**Location: 98 Rochester Road and land adj 94 Ribchester Road Clayton-Le-Dale BB1 9HQ**  
**Proposal: Approval of details reserved by conditions 9 (SW drainage), 12 (drainage scheme)**

Further to our review of the submitted documents, Drawing Proposed Drainage Layout, Dated December 2024, United Utilities recommends that conditions 9 and 12 are **not discharged**. This is because:

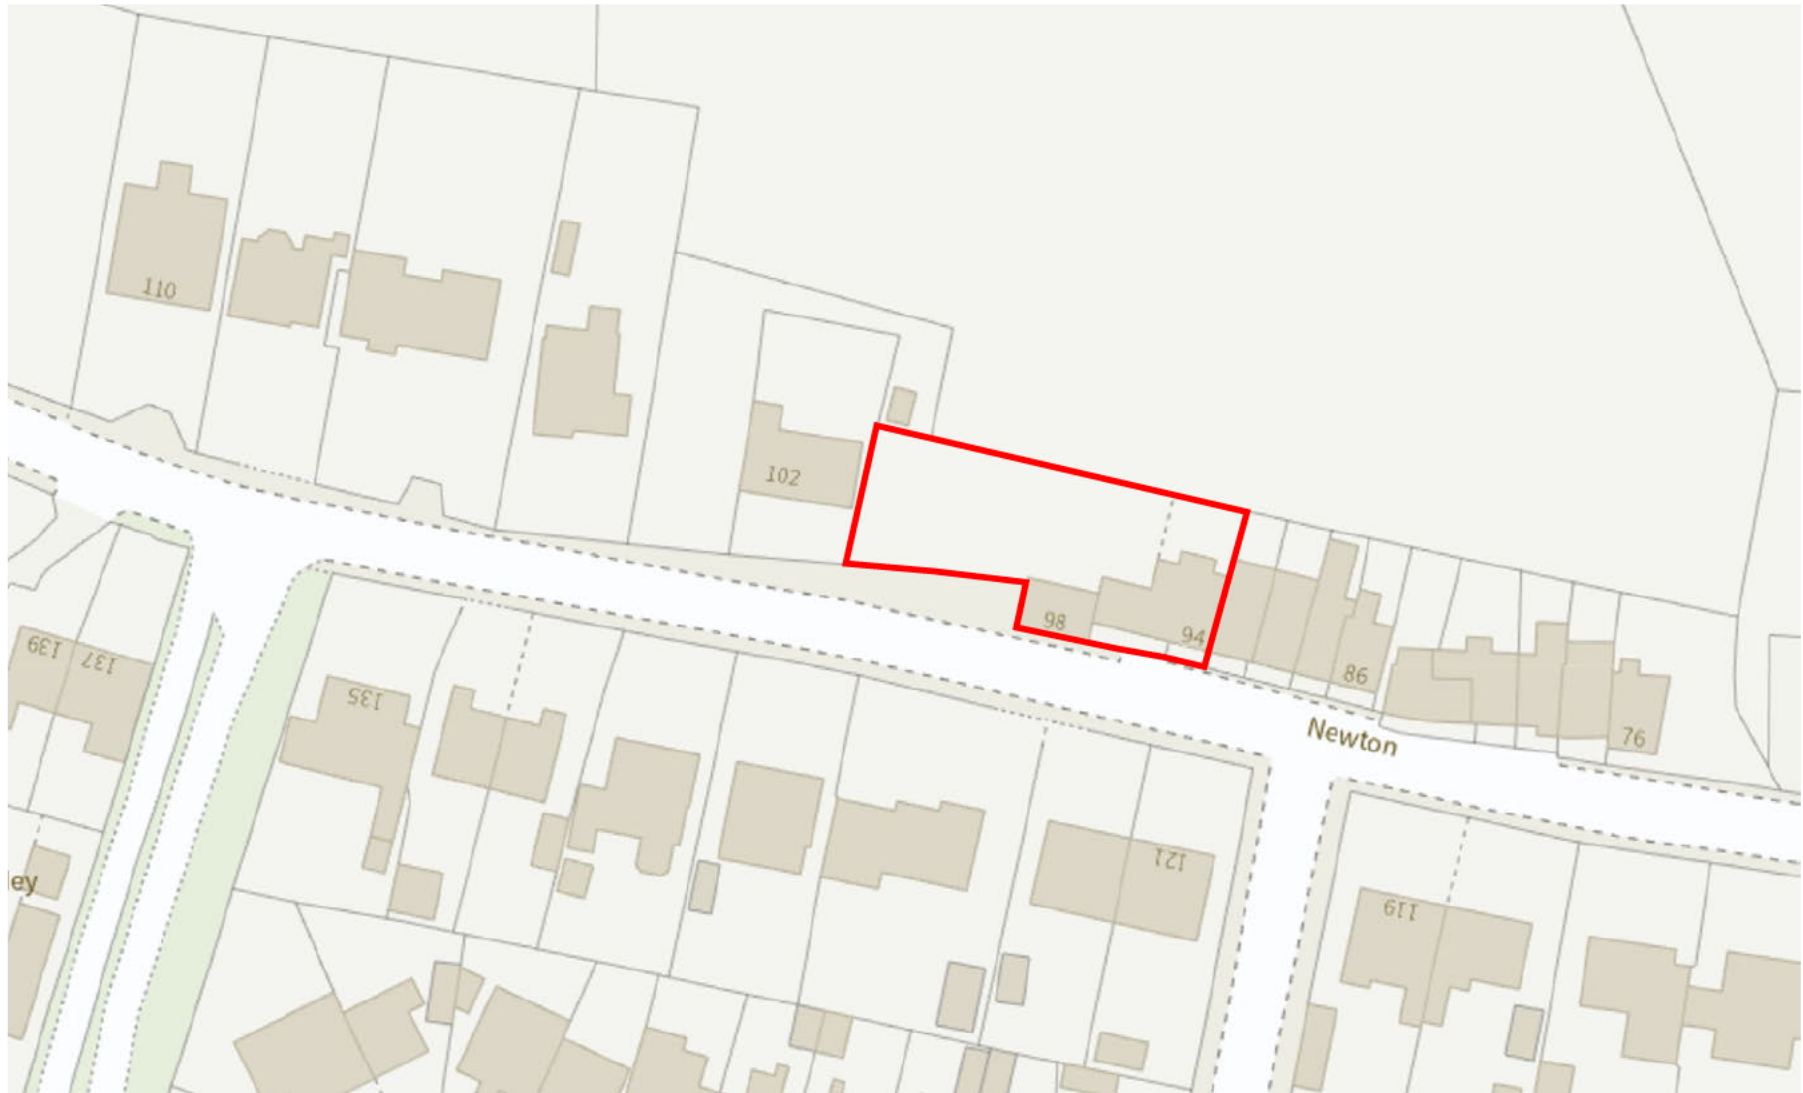
- It is unclear how the connection is being made with the public wastewater network. We require a detailed drainage plan; clearly demonstrating how the scheme would connect to the public sewer. Noting that this is an application to discharge drainage conditions, we would expect the invert levels and cover levels to be included on the drainage plan.
- The sewer shown on our records is being assumed to be a combined sewer. The asset maps indicate it is a foul only sewer. We require evidence i.e. a drainage survey, to confirm that the foul sewer we have on our records is in fact a public combined sewer.
